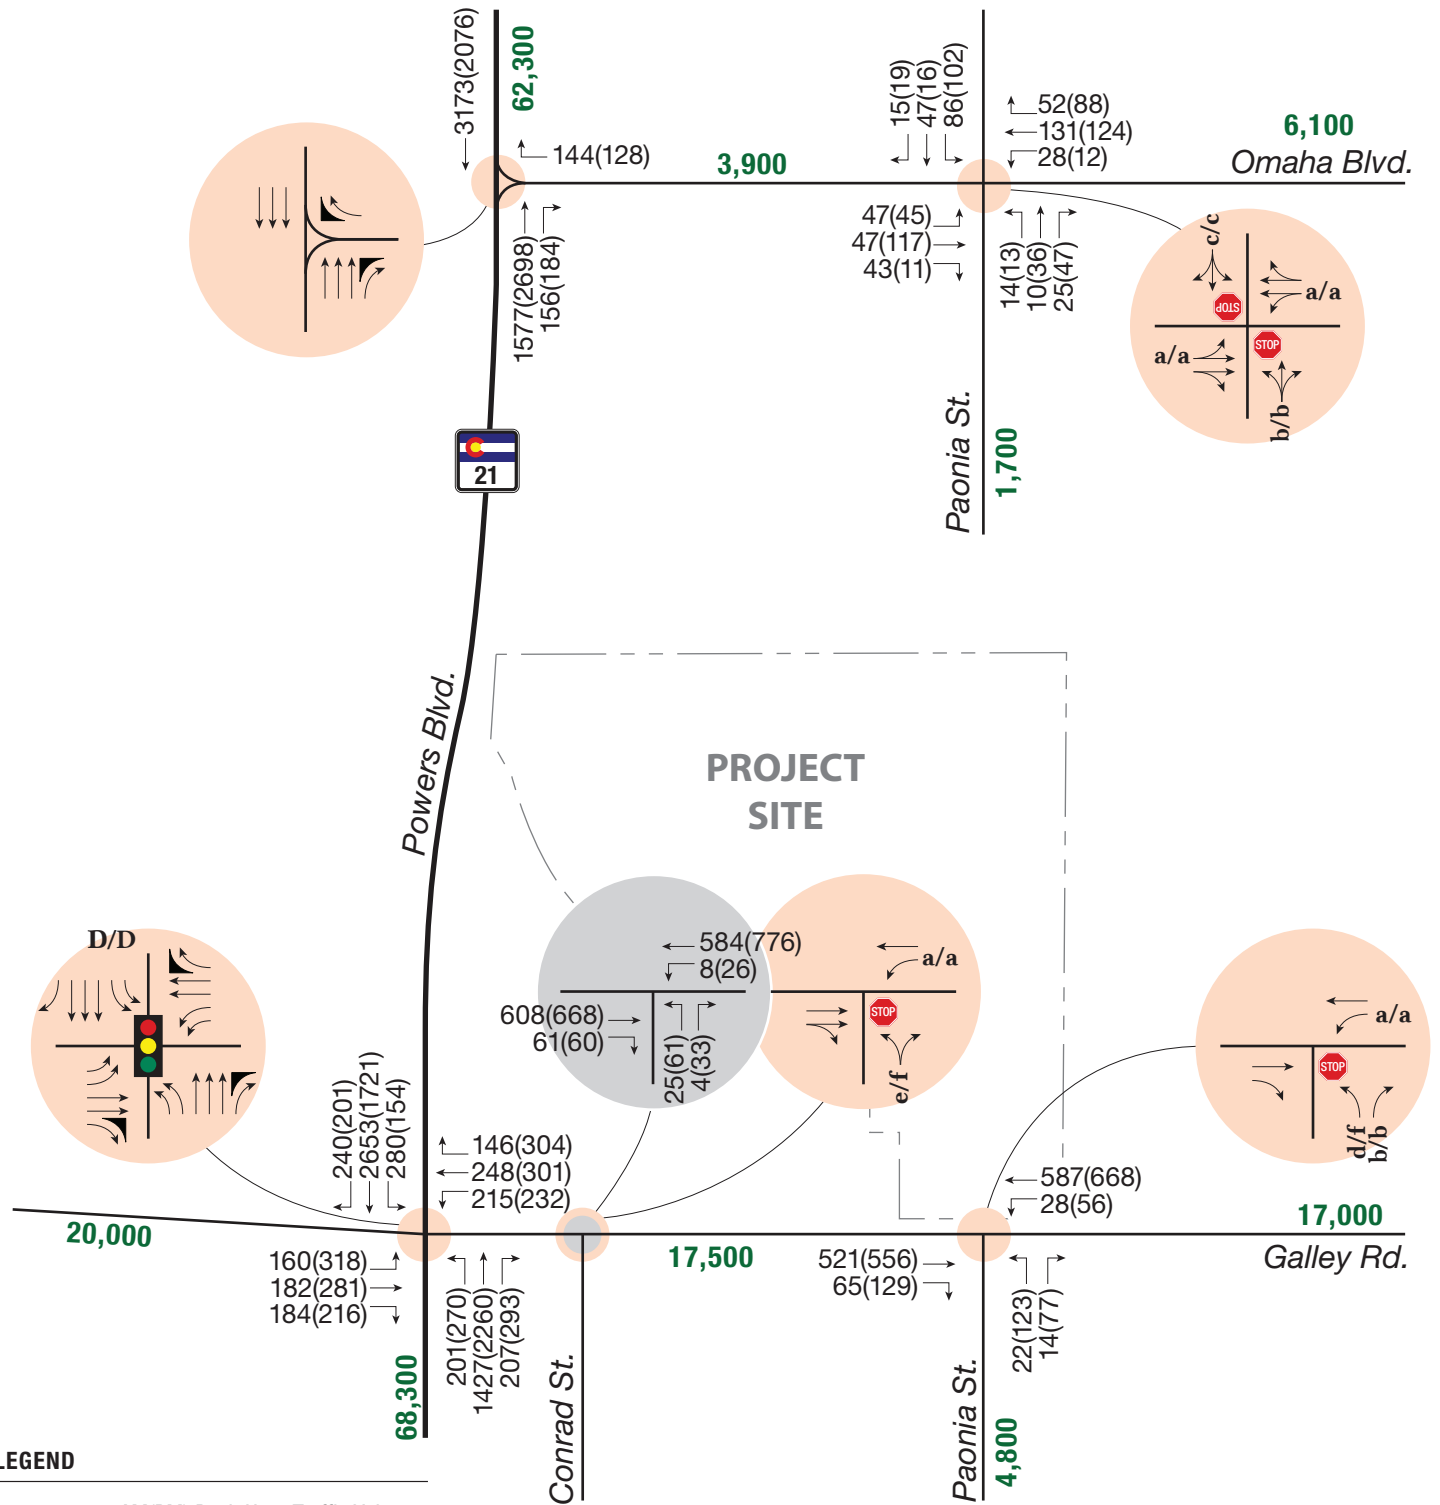
Existing southbound traffic at Powers & Galley on
Figure 3 does not match the traffic counted in the
appendix. Please revise

Adjustment made to increase assignment to Powers south of Galley and reduce Galley west of Powers	14/15
Southbound traffic shown on Figure 3 does not match counted volume because adjustments were made upward to reflect a balanced volume with the Omaha St intersection to the north. No changes made to report	NA

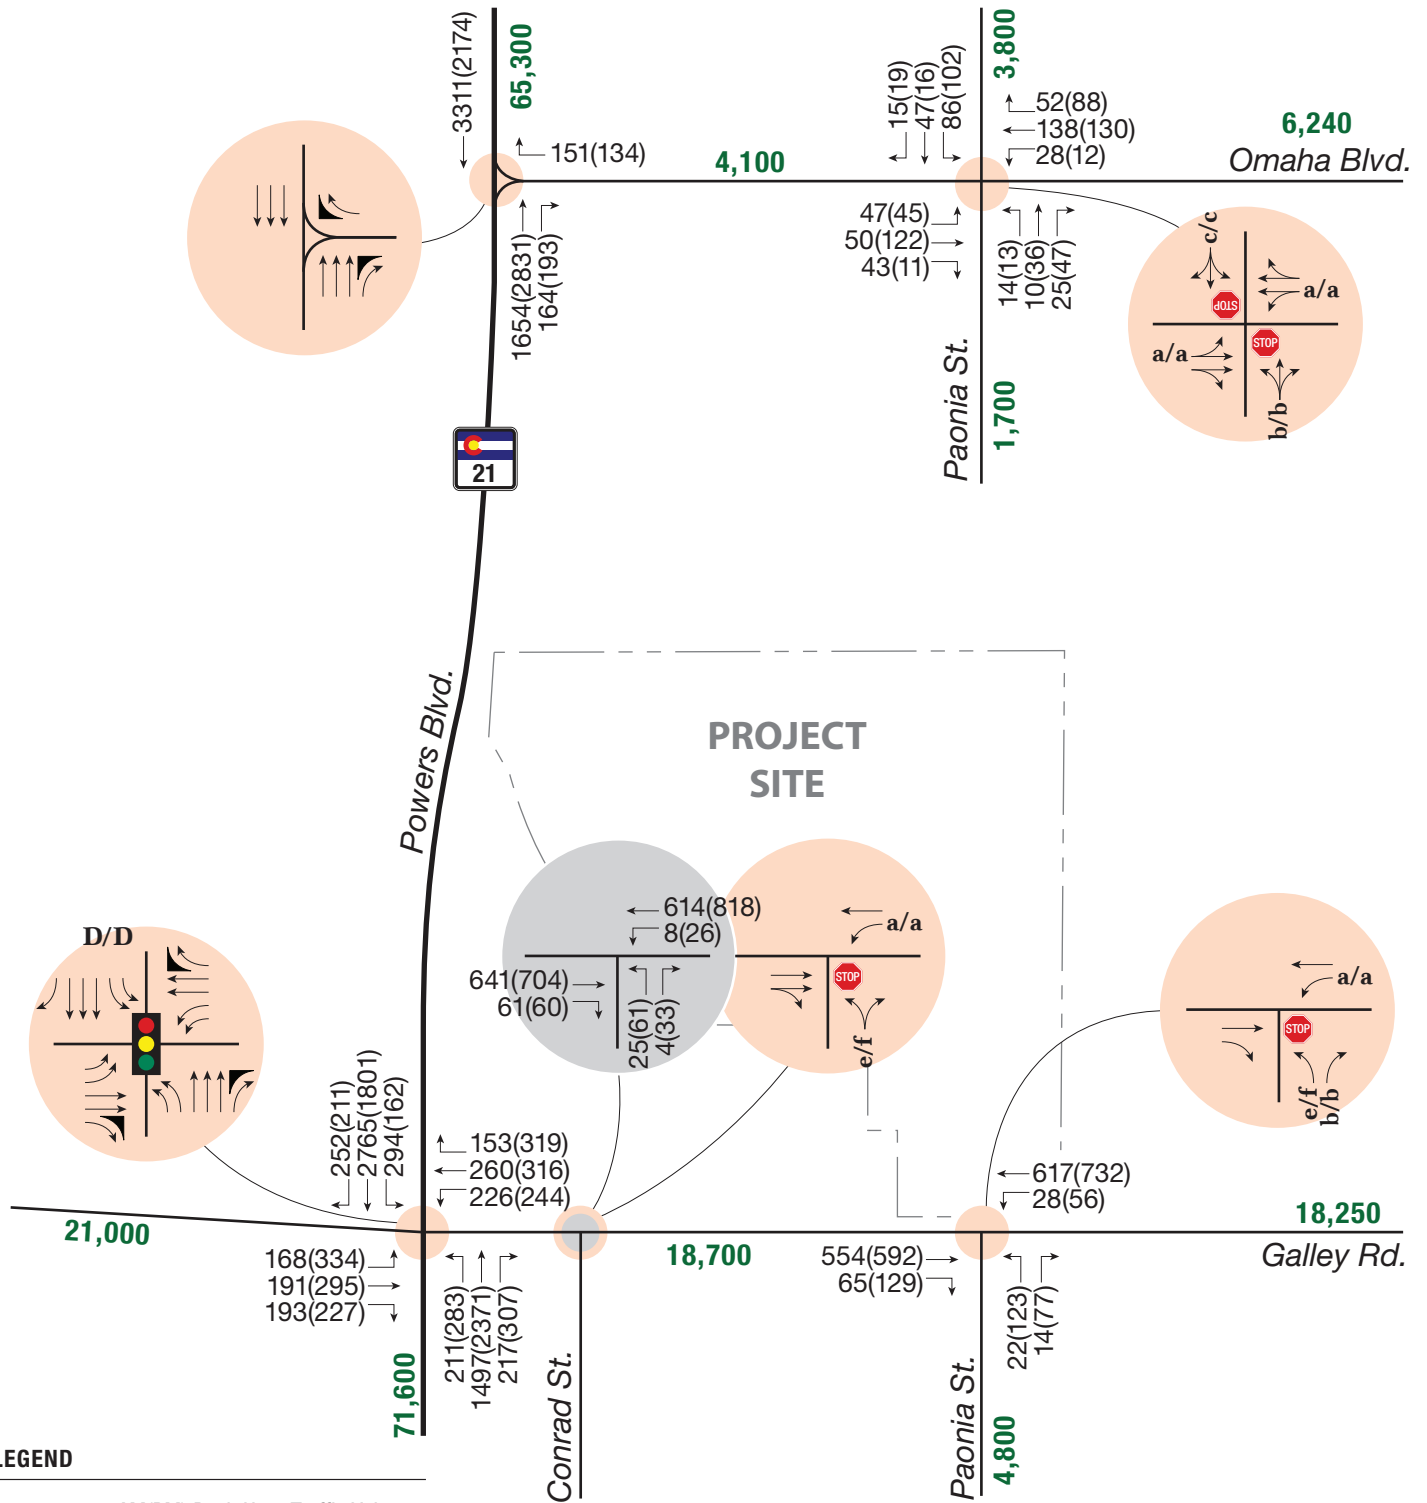
The total deceleration lane length should be 315 ft. Please revise
El Paso County		21	
El Paso County		21	I believe you meant table 4 instead of 54. Please also include westbound left turn lane. The
El Paso County		21	volumes provided warrant a westbound left turn. The timing of the improvements should be listed in terms of the Phases/Final Plat filings proposed. Looking at the preliminary plan, it appears that these improvements would be required with Phase I/Initial Final Plat application as both access points and most of
El Paso County		24	the buildings are part of Phase I. Please revise. The developer will be responsible for constructing the sidewalk along the property frontage with Phase I/initial final plat application. The rest of the
El Paso County		24	sidewalk that will extend to Powers blvd may be listed Section IV.C assigns 30 percent of site trips to Galley Rd west of Powers as a means to reach downtown Colo Spgs. Calculating directions with Google Maps indicates that Platte Ave is the preferred route for such trips. Powers Blvd provides the most direct link for such trips. Inbound traffic from downtown would exclusively use Powers Blvd as such movement would avoid traffic signals. The outbound movement would utilize the westbound left turn at Powers Blvd and only be limited by the capacity of such turning movements at which point an alternate street to the west would be used to reach Platte Ave. Trip distributions should be adjusted accordingly, please revise.

Lane length has been recalculated and revised to be consistent with County standards	22
Typo fixed in update	22
Westbound left turn lane added in update	22
